Amendments to design approved under FG/95/16/PL, polytunnels, outdoor growing beds, tree nursery, storage & welfare facilities for a horticultural enterprise.

Quercus Nursery Littlehampton Road Ferring

Thank you for your internet representation made on 30th May 2018 which has been recorded as **'an objection'** with the comments as follows:

PROPOSED Polytunnel Plans

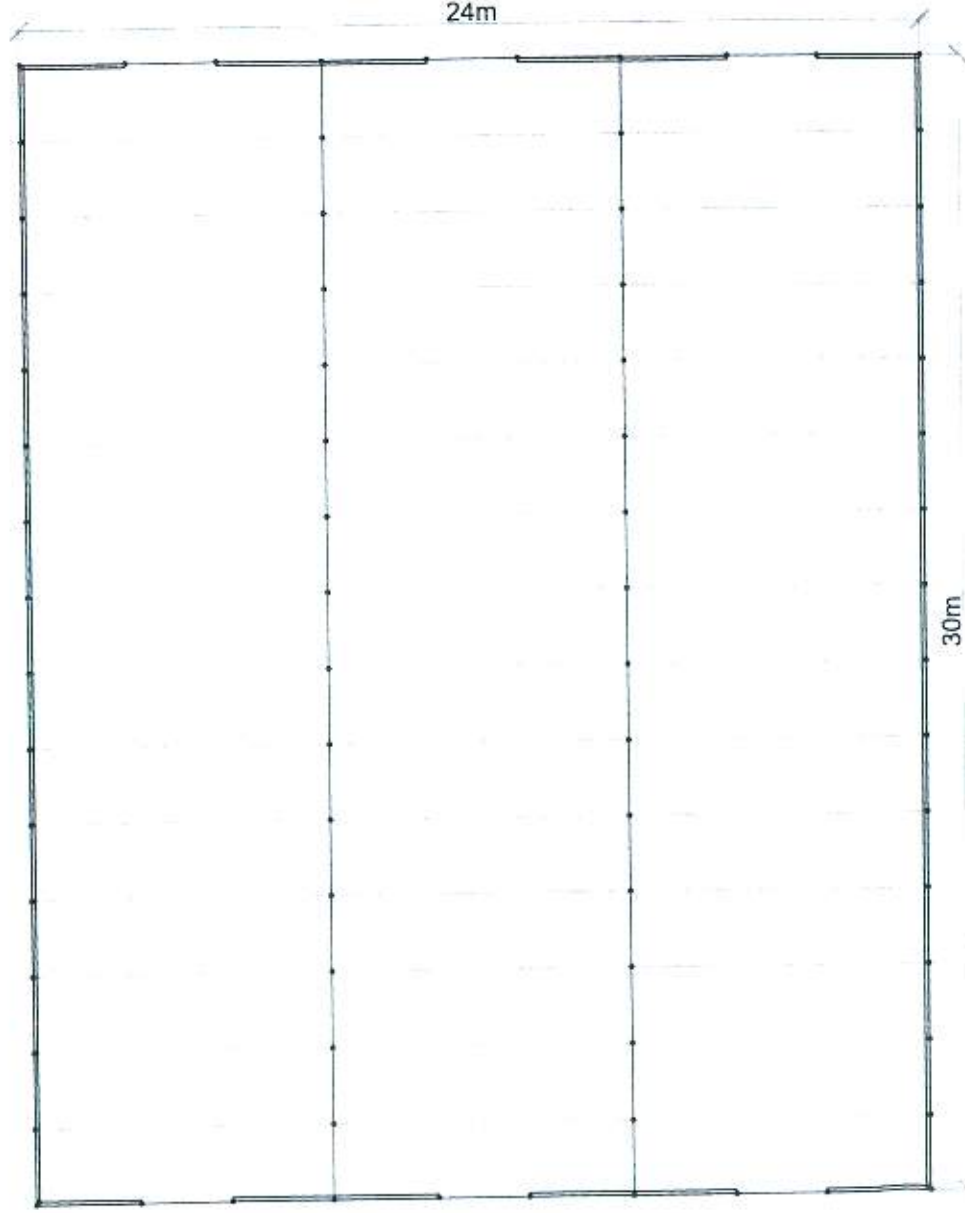
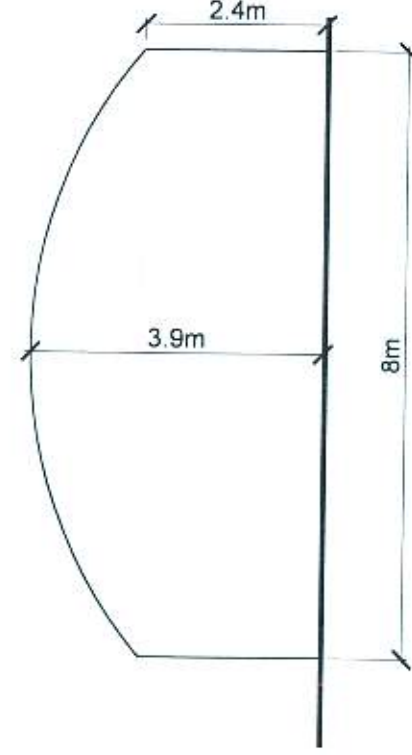
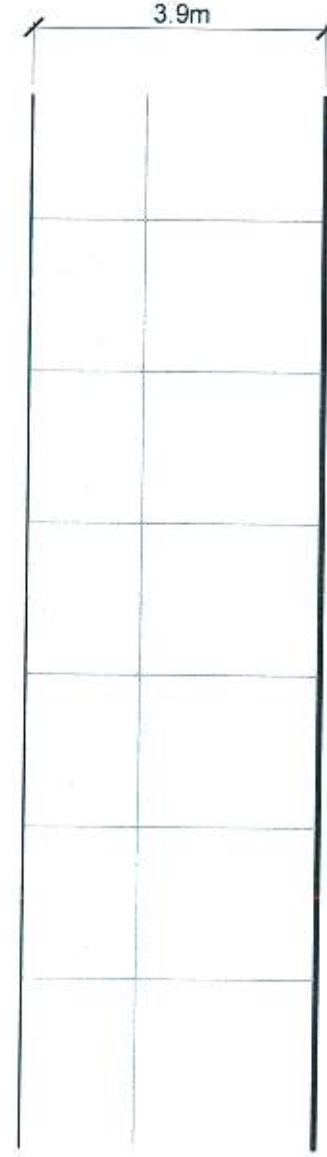
Dear Sirs, I live almost opposite the site. I would like to object to the application on the basis of the increase in size of the Polly Tunnels, this would be an eyesore for the neighbouring properties. Also it should be noted that I am regularly disturbed each week at approximately 3am by excessive noise coming from the site, if you permit the application a strict 9 - 5 trading hours should be made a condition.
